Re: Objection to MP08_0244 MOD 1 Modification Request for Mixed Used Development at 23-37 Lindfield Avenue and 11 Havilah Lane, Lindfield

As a resident of Lindfield, I/we wish to lodge an objection against the proposed Modification of the subject development based on the following grounds:

1 SHADOW DIAGRAM - 21stDEC_9AM
5003 SCALE1 : 650

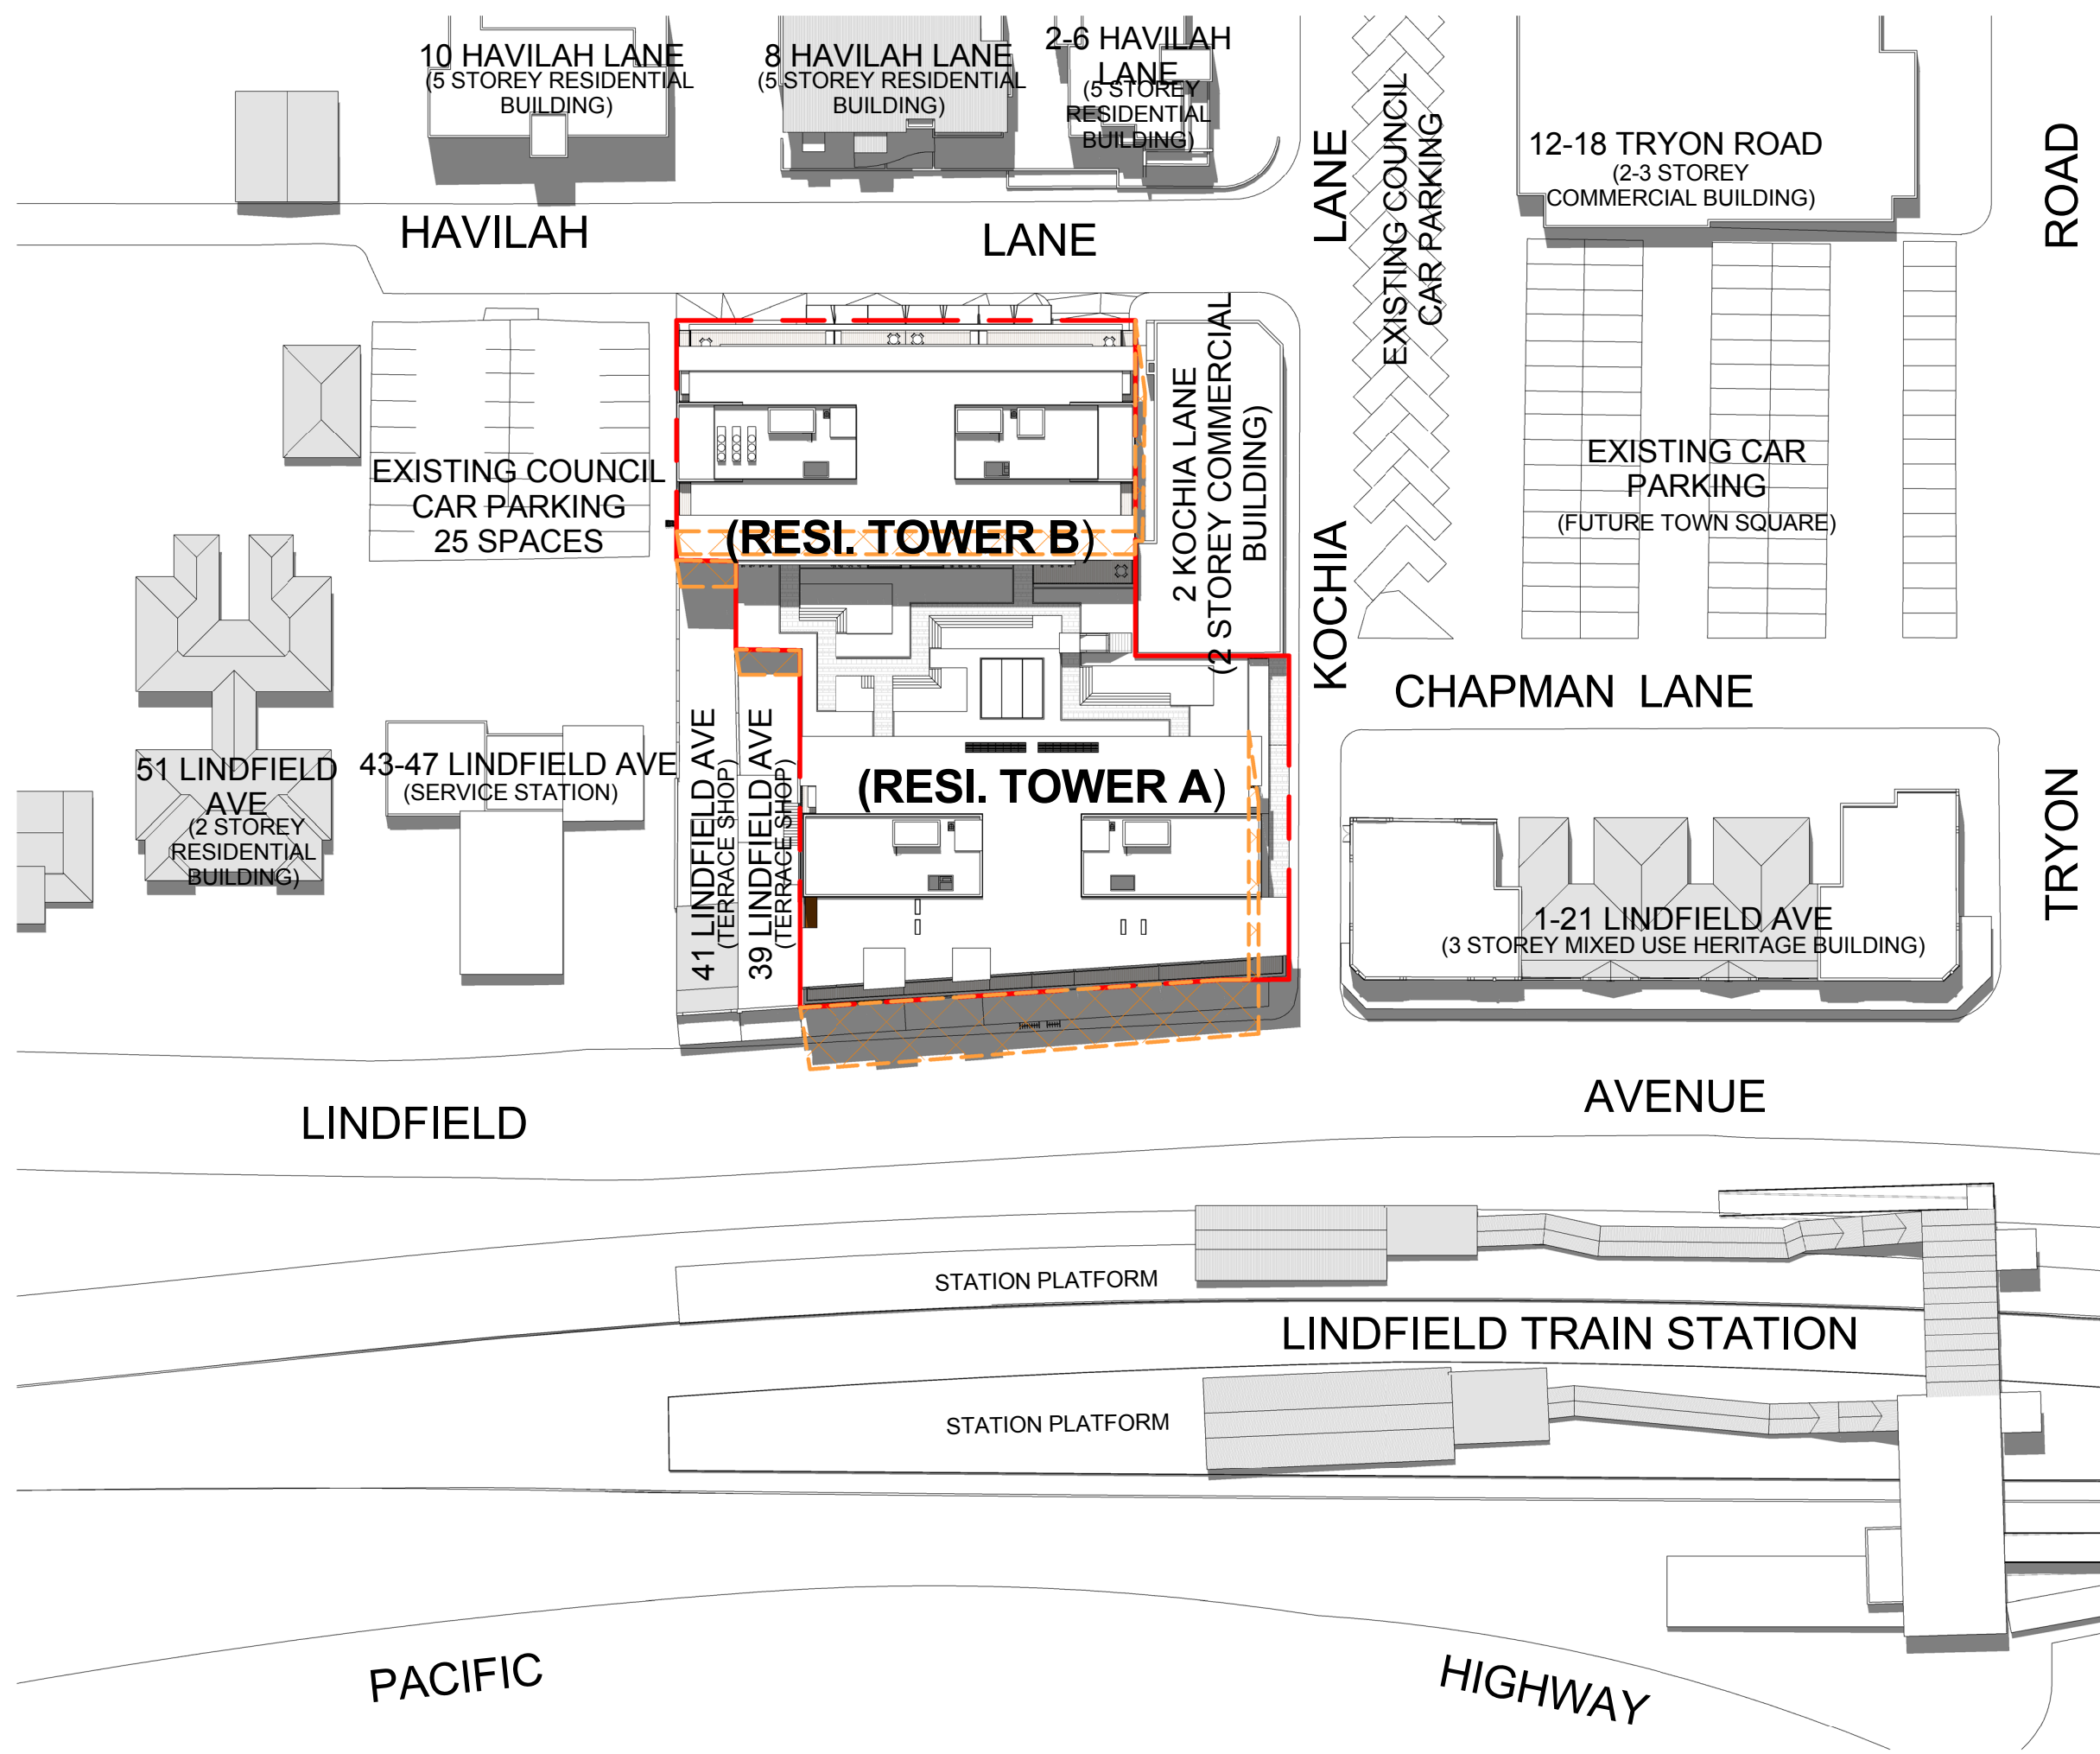
- The additional storeys create new adverse shadowing: a) for residents in the Havilah Lane apartments particularly after 3pm b) for the popular outdoor café and central Lindfield hub area at 12 Tryon Road in afternoons, particularly in winter and c) for all commuters on the city bound Lindfield rail platform, instead of 50% of the year as approved, it will now be in shadow in the mornings 75% of the year
